Our Ref: BN/23/19/HH

**Town & Country Planning Act 1990 (as amended)
Town & country Planning (Development Management Procedure) (England) Order 2015
Application for Planning Permission for Works or Extension to a Dwelling**

Development 2-storey side extension
Location Rievaulx Cottage Lake Lane Barnham

BLOCK PLAN scale 1:500

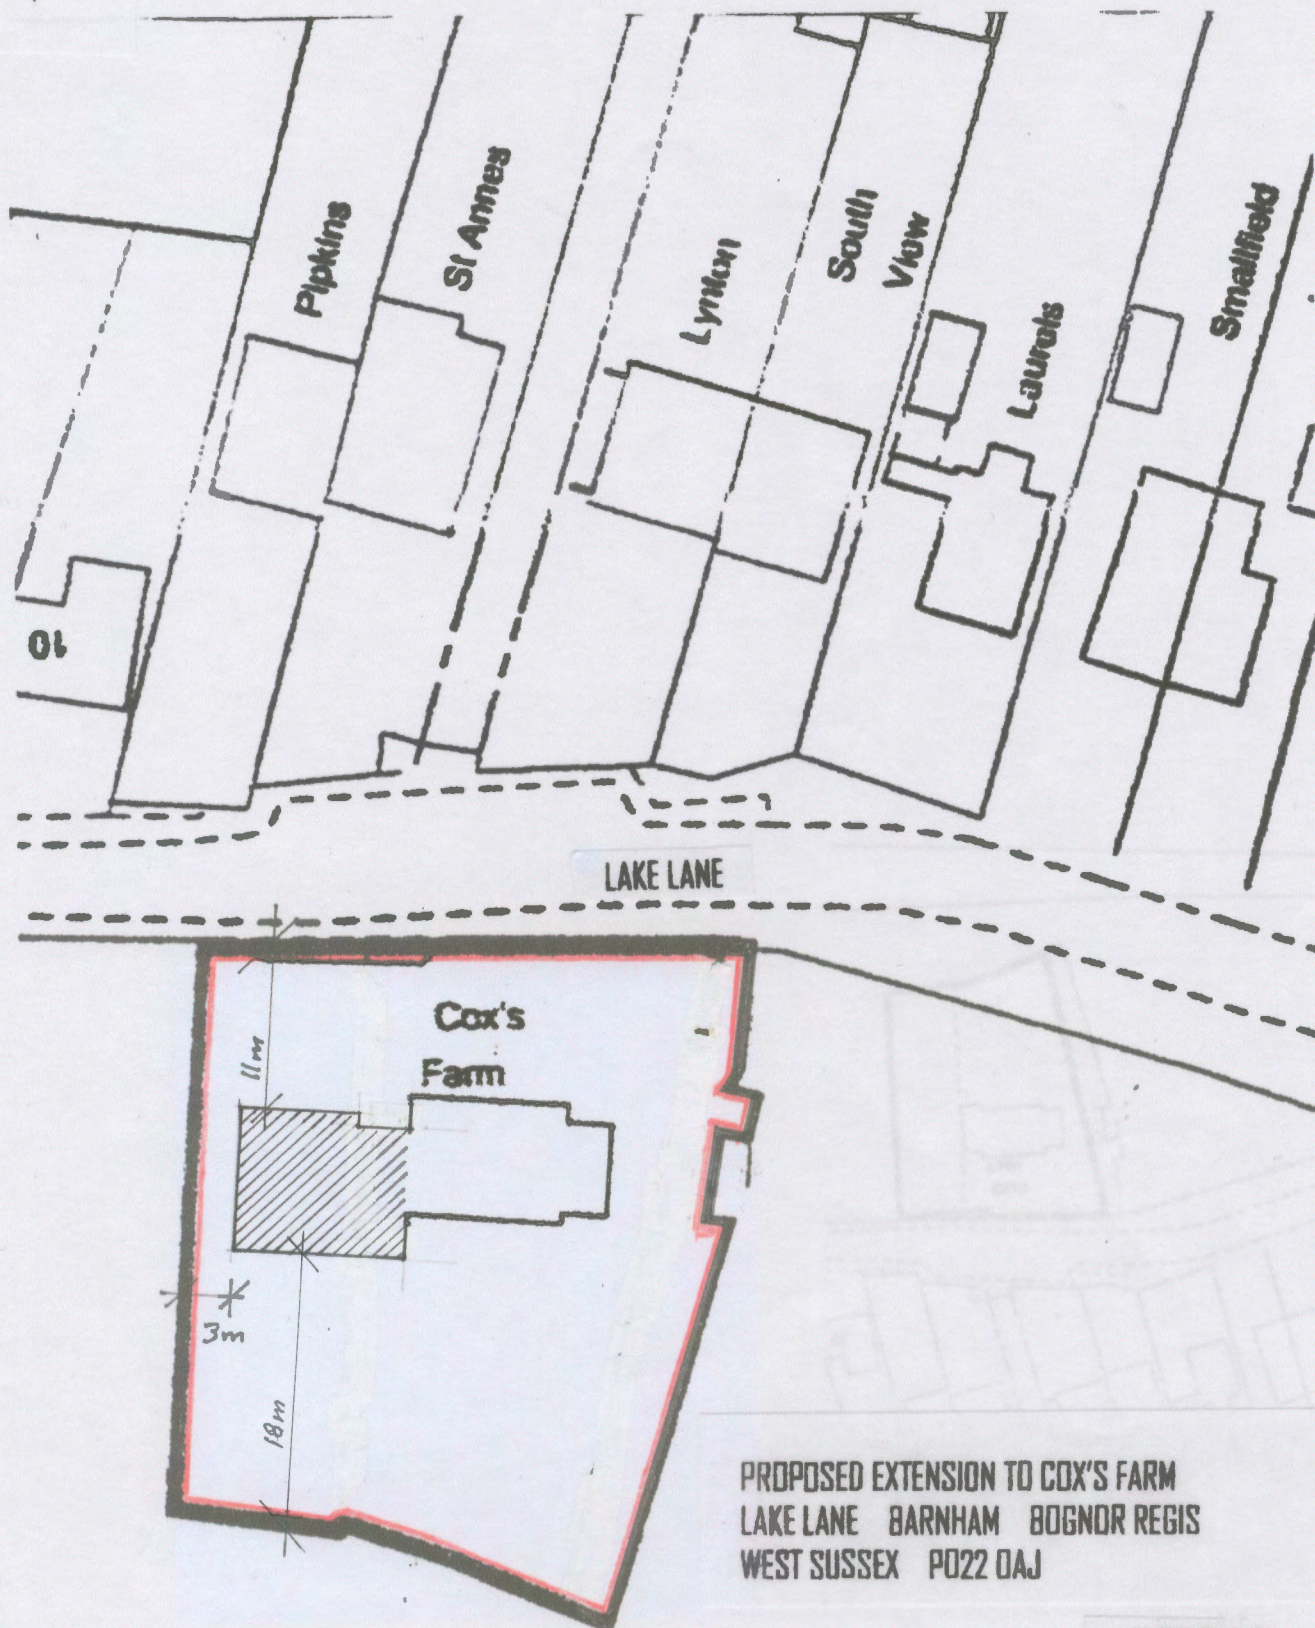
Block Plan

Please include a dimensions to the rear boundary on the block plan.
